Subject: RE: BR/320/18/PL and BR/321/18/L

I do understand your point and after consulting our Conservation Officer I have changed the wording of this pre-commencement condition:

Subject: BR/320/18/PL and BR/321/18/L

PROPOSED ELEVATIONS

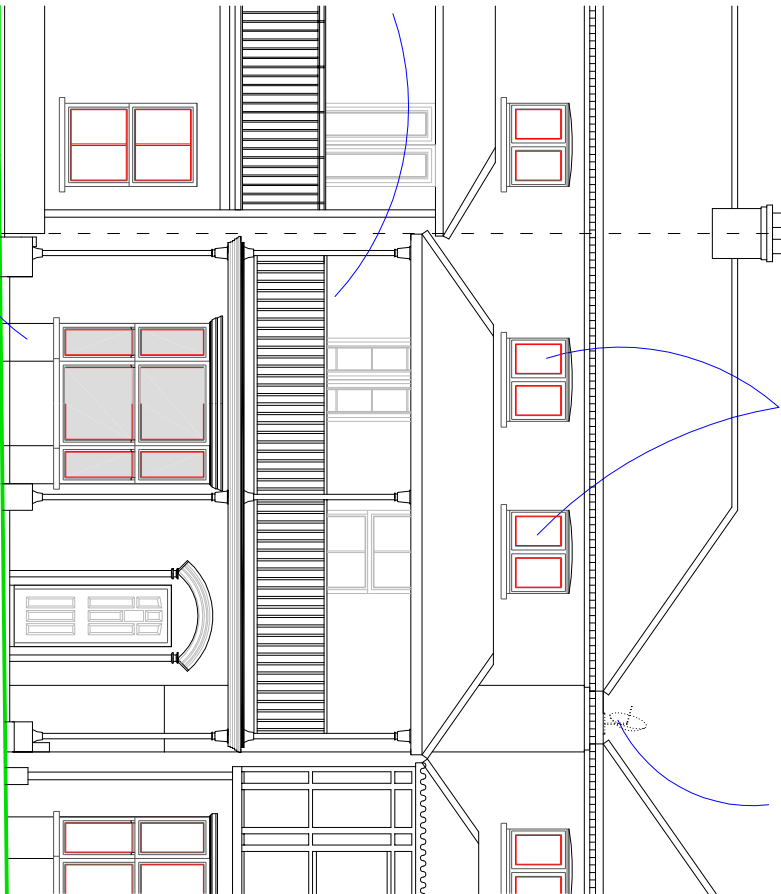
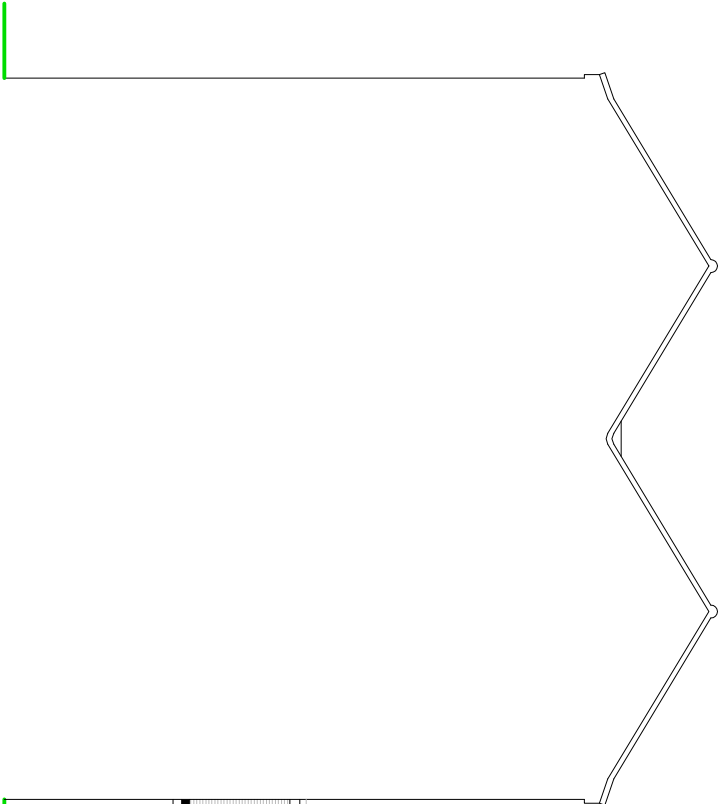
No new windows shall be inserted and railings fixed until details of new windows and railings have been submitted to and approved by the Local Planning Authority and implemented in accordance with the approved details.

It is our understanding that this condition should only be in respect of the front bay window and the railings to the balcony.

No development shall take place unless and until details of new windows and railings have been submitted to and approved by the Local Planning Authority and implemented in accordance with the approved details.

We are pleased to accept the condition as stated in your email, and for the avoidance of any doubt we confirm that no railings or windows will be fitted until approval has been obtained from the Council's Conservation Officer.

We will of course submit details of the railings and windows as soon as possible and work with the conservation officer on the front elevation to ensure that it is in keeping with the conservation area.
